**KIRKLEES METROPOLITAN COUNCIL  
INVESTMENT & REGENERATION SERVICE**

**DELEGATED DECISION TO DETERMINE PLANNING APPLICATIONS**

Reference No:	<b>2025/62/91983/W</b>
Site Address:	40, Peel Street, Marsden, Huddersfield, HD7 6BW
Description:	Installation of replacement shop front (within a Conservation Area)
Recommending Officer:	Molly Storer

## **OFFICER REPORT**

PROPOSED ELEVATION SKETCH

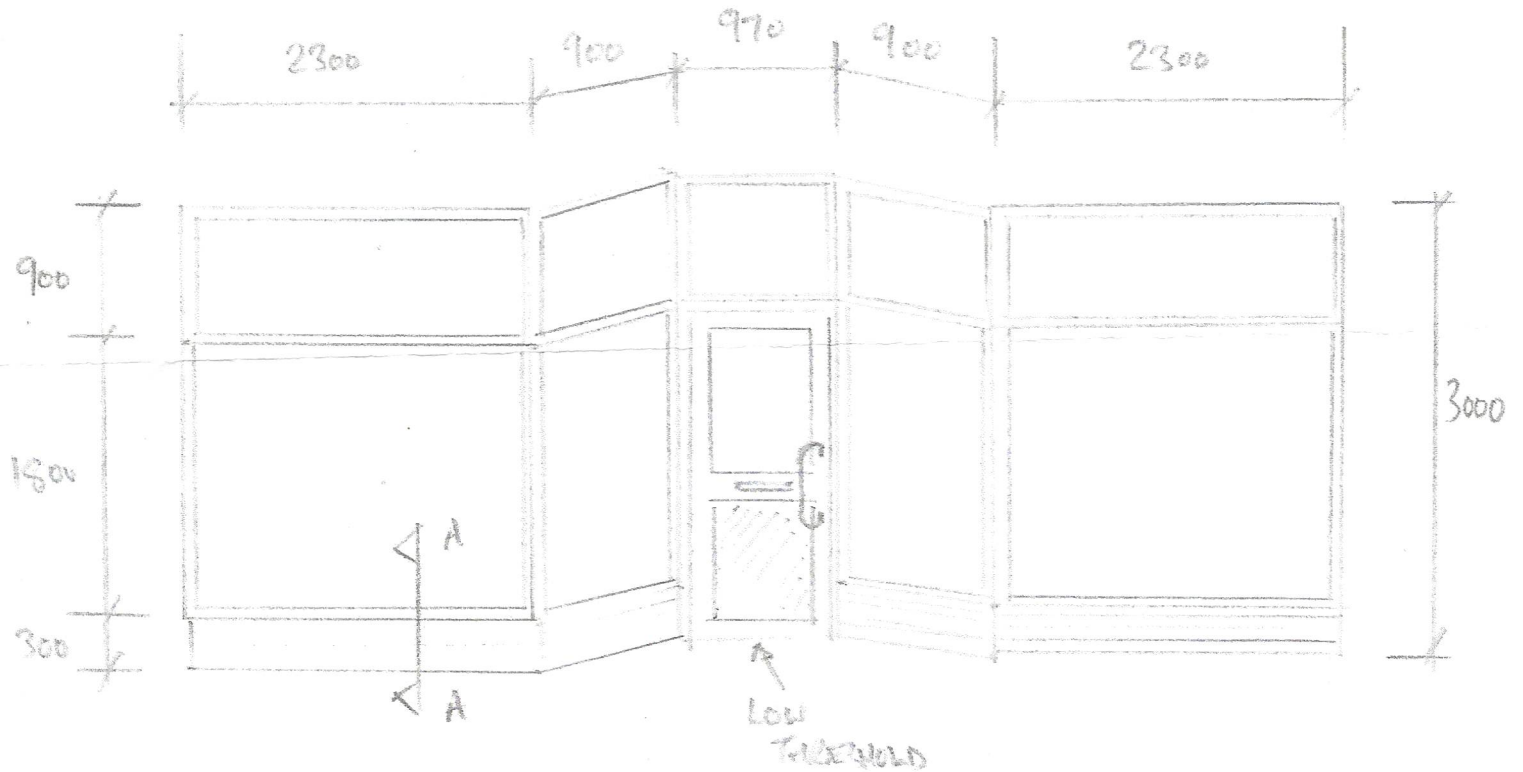
Therefore, with regards to replacing the shopfront it was originally suggested that features such as thicker turned mullions should be included in the design. A joiner was contacted who stated that fully turned mullions would not be possible as the wood needs to be thick in order to hold the double glazing. However, the corners of the windows could be rounded to maintain more traditional design. This was accepted by the Conservation and case officer.

- There isn't enough information on how the shopfront will retain local distinctiveness and heritage value.
- The shopfront currently has turned mullions but it is not clear whether these are being retained.
- The application doesn't give information of whether the shopfront could be repaired.

2. Notwithstanding the submitted information the corners of the shopfront where the turned millions currently are shall be rounded and thereafter be retained.

3. Notwithstanding the submitted information the shopfront shall be constructed from timber and clear glazing and thereafter be retained.
